# Appeal Decision

**Appeal Ref: APP/T2350/W/16/3151566**

**Field Barn, Old Langho Road, Langho, Lancashire, BB6 8AW**

drawing title:
 GARAGE SCHEME DESIGN

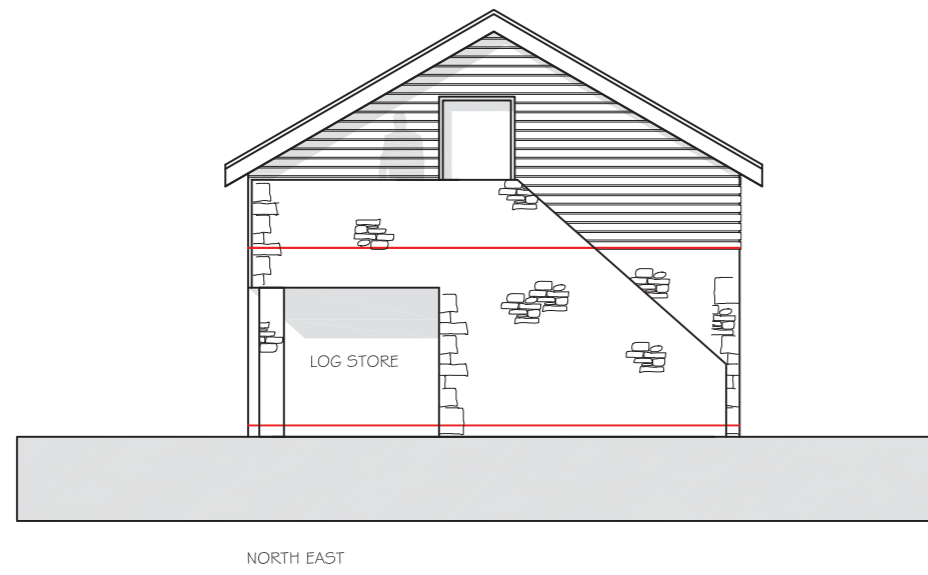
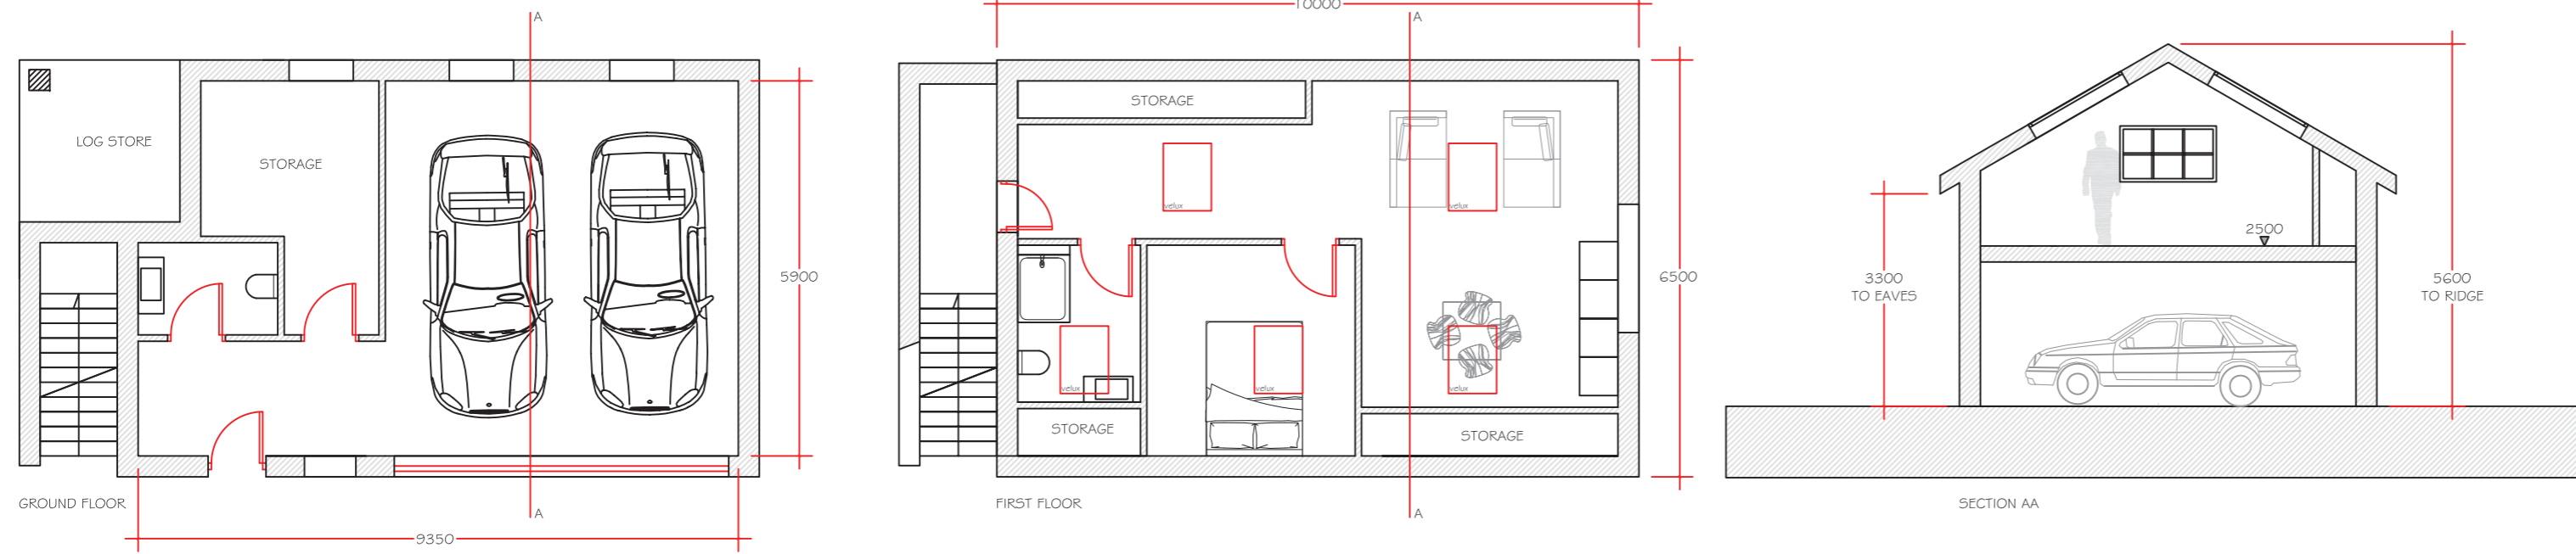
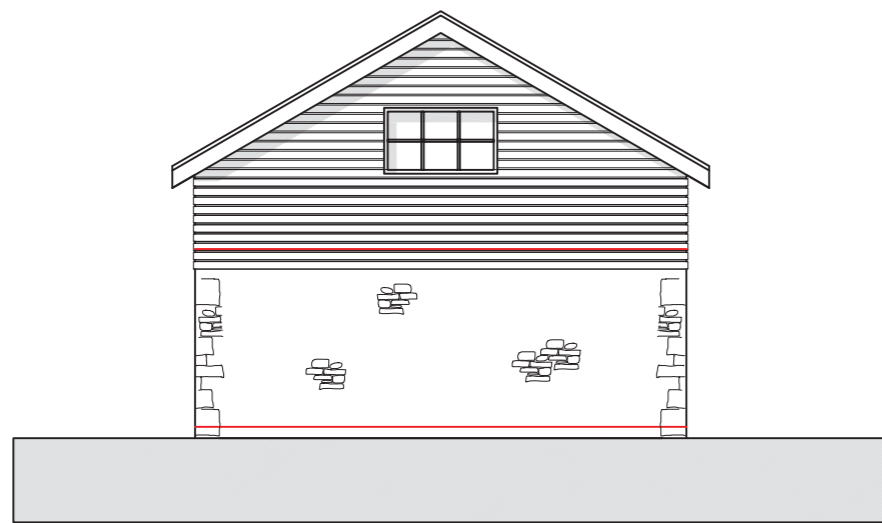
6. The proposed garage / annexe building would be taller and more imposing in stature. In particular, it would be higher than the eaves of the existing dwelling and the recent additions to the original barn. Due to its size, height, and position, it would not be subservient to the existing dwelling and would appear overly dominant. In addition, its design would be domestic in appearance, and it would have a disproportionately sized garage door. It would therefore not be sympathetic to either the existing dwelling or the wider area. Whilst the land that the building would occupy is currently used for car parking, this has a lesser impact on the appearance of the area than the proposed garage / annexe building. Furthermore, the recent approvals to extend the original barn are not comparable to the current appeal proposal, as these are single storey subordinate additions to the existing dwelling.

9. For the above reasons, I conclude that the proposed garage / annexe building would unacceptably harm the character and appearance of the area. It would therefore be contrary to Key Statement EN2 and Policies DMG1 and DMG2 of the Ribble Valley Core Strategy (2014).

PROPOSED STABLE 1:100

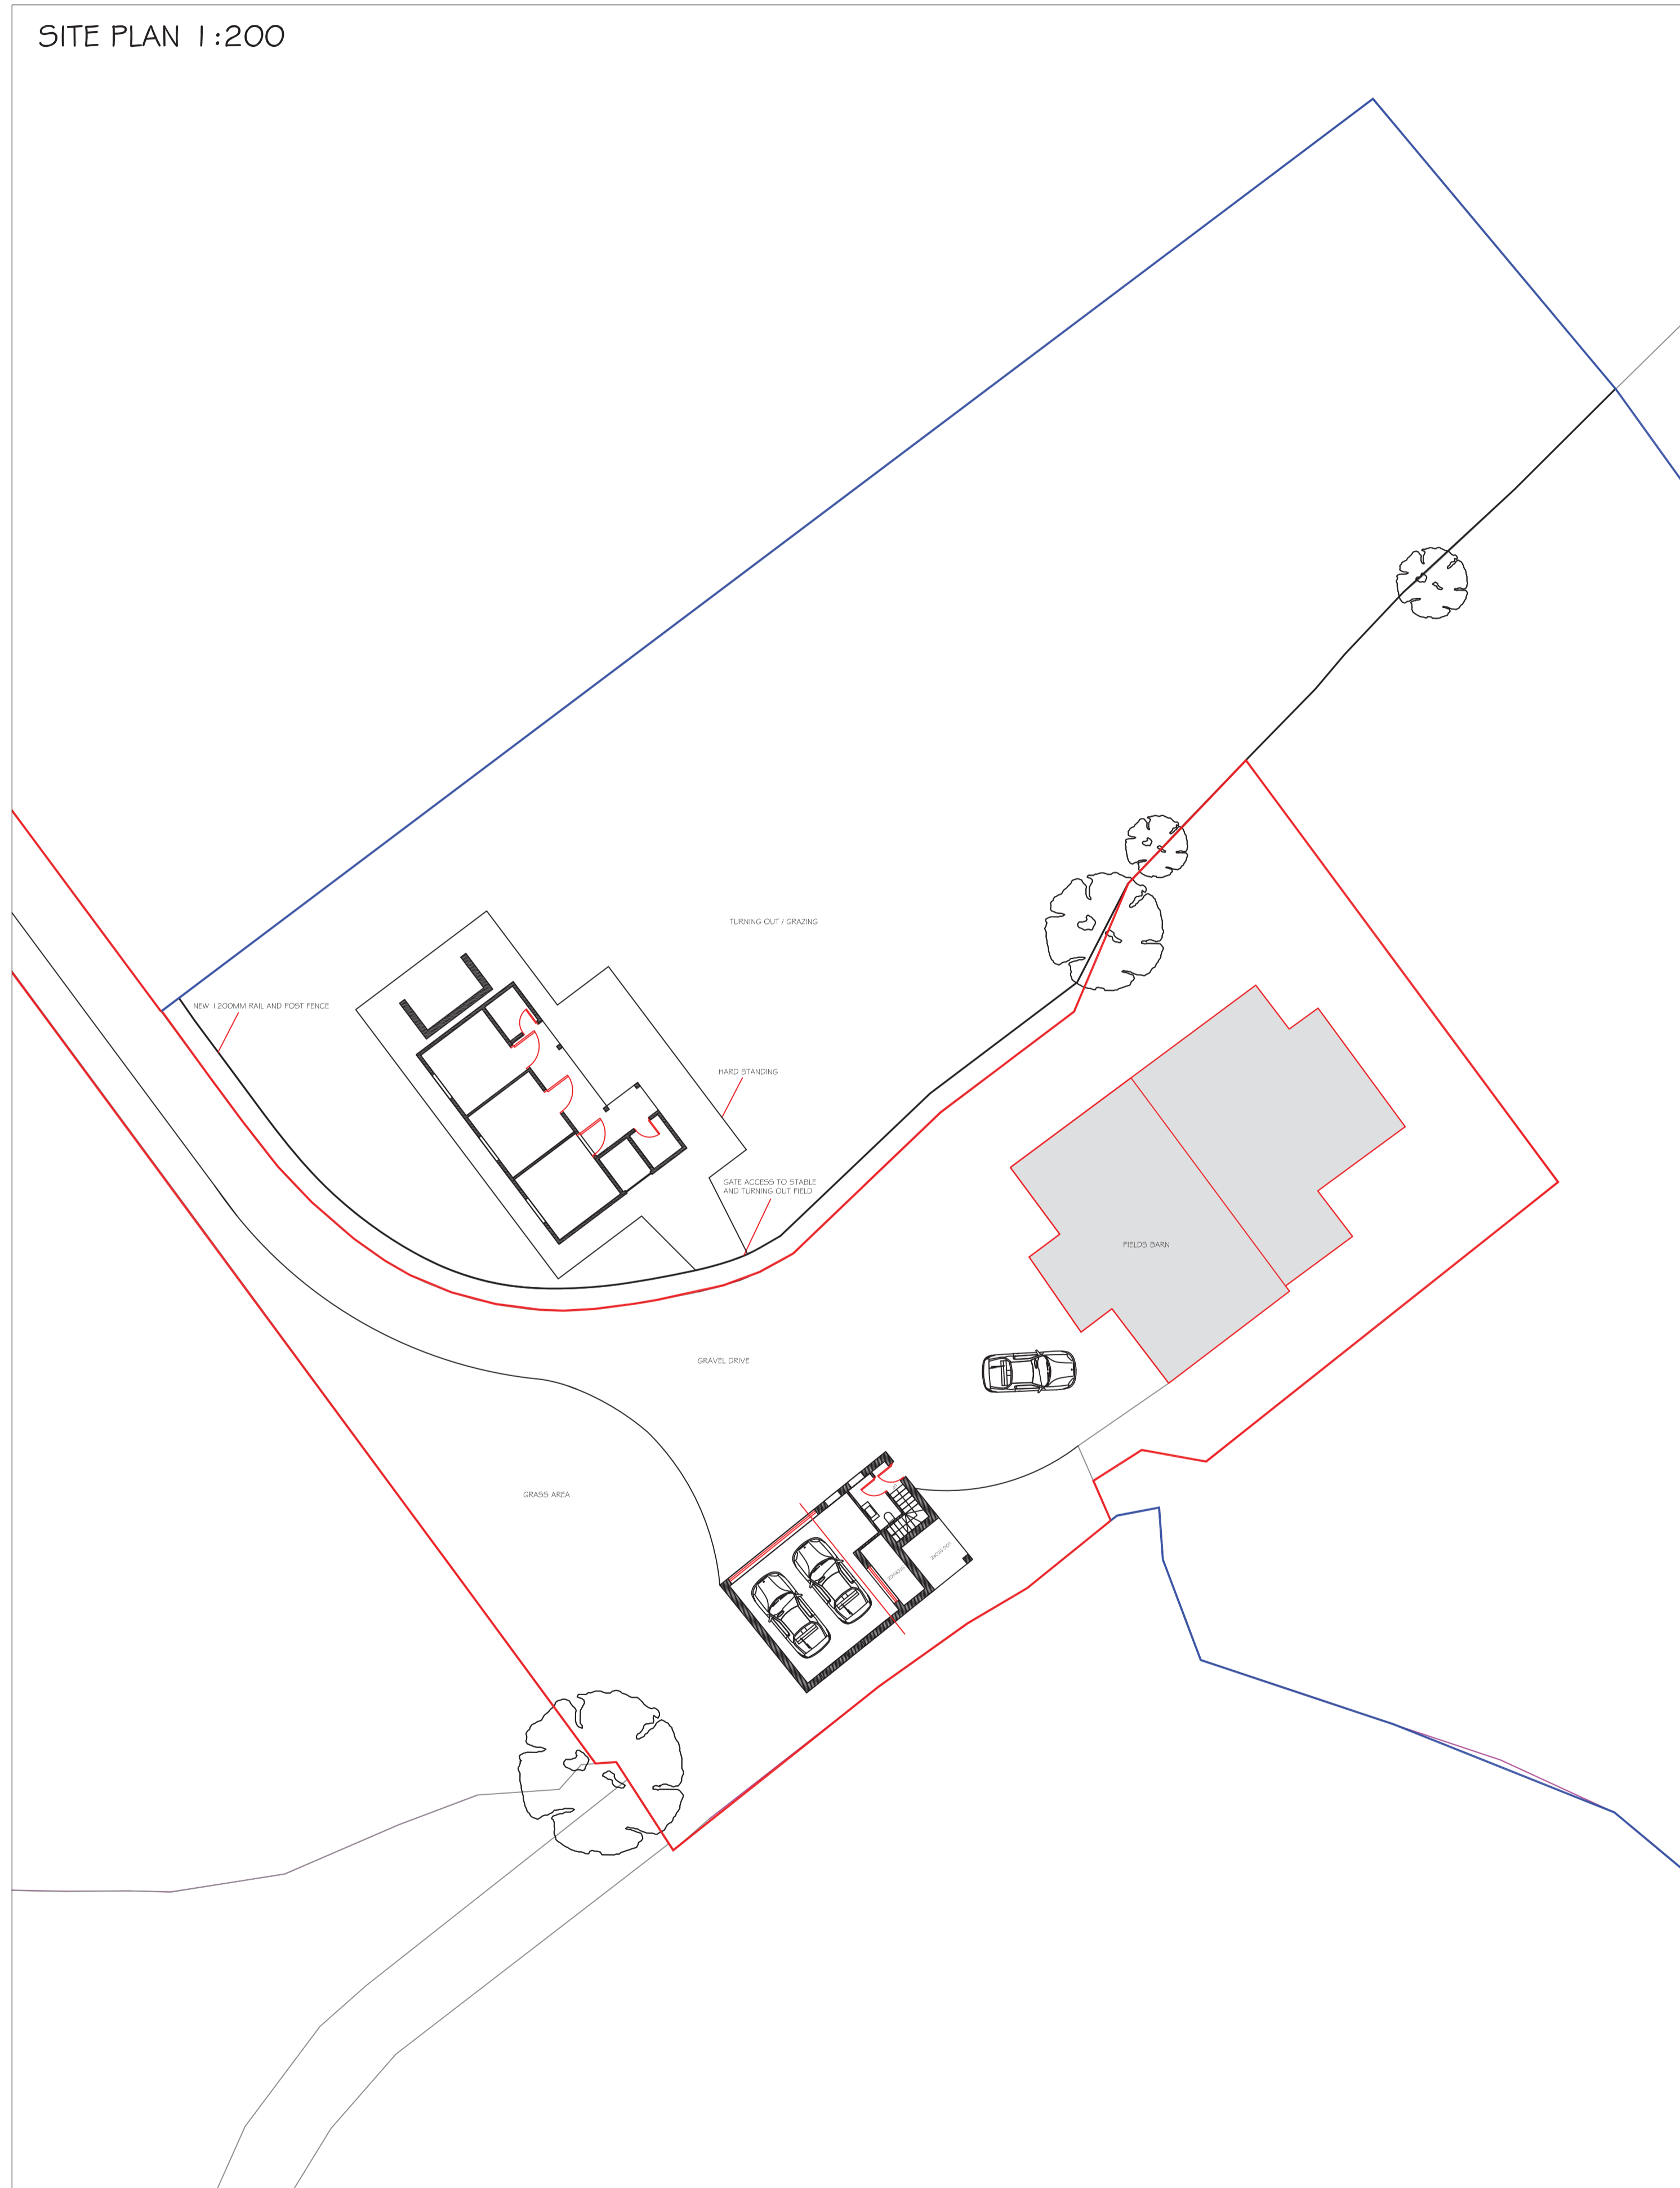
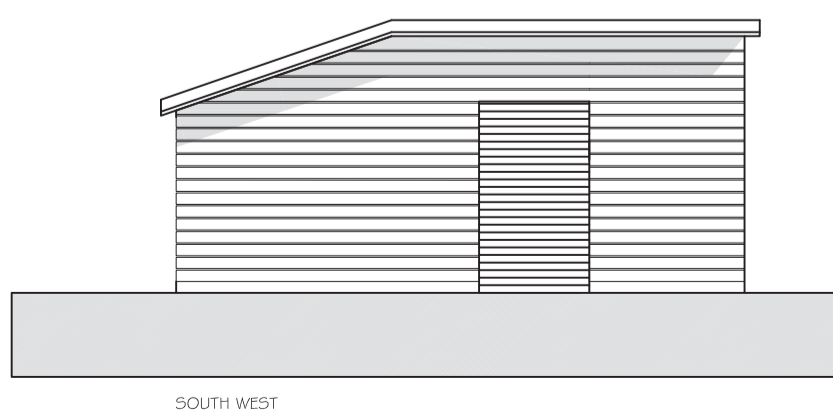
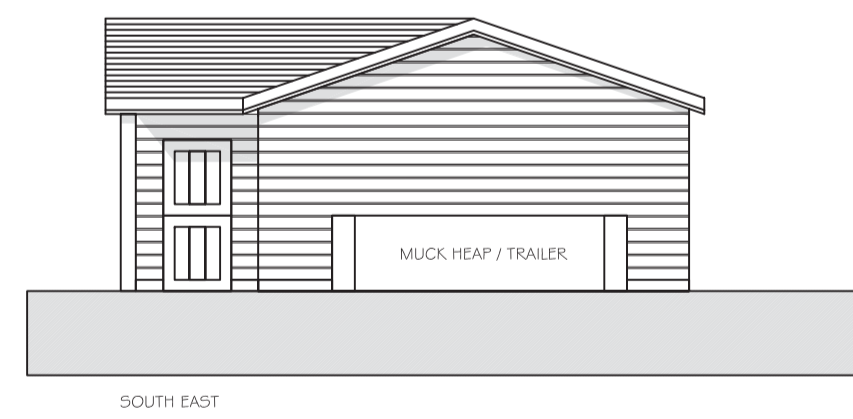
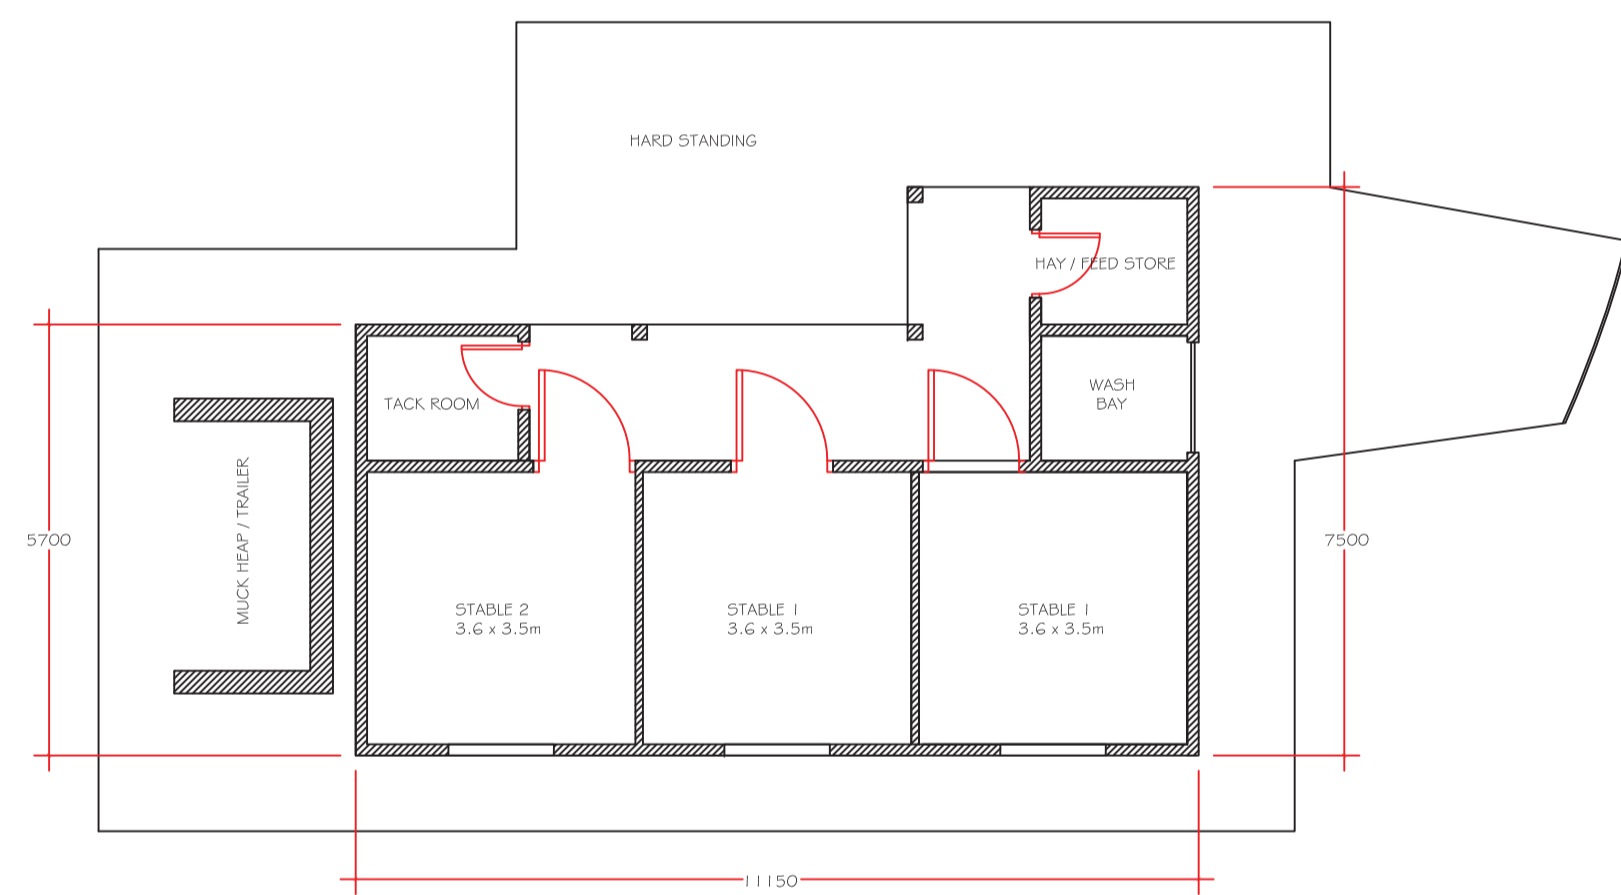
5. The proposed stable block would be a low single storey building of wooden construction. It would be modest in stature and subservient to the existing dwelling. It would also be of a design and development type that would be typical of a rural location, and it would be in keeping with the surrounding rural landscape. It would not be harmful to the character and appearance of the area in my view.

10. Separately, I conclude that the proposed stable block would not unacceptably harm the character and appearance of the area. It would therefore be in accordance with Key Statement EN2 and Policies DMG1 and DMG2 of the Ribble Valley Core Strategy (2014).

- 1) The development hereby permitted shall begin not later than 3 years from the date of this decision.
  - 2) The development hereby permitted shall be carried out in accordance with the following approved plan: PHD/FB 100.
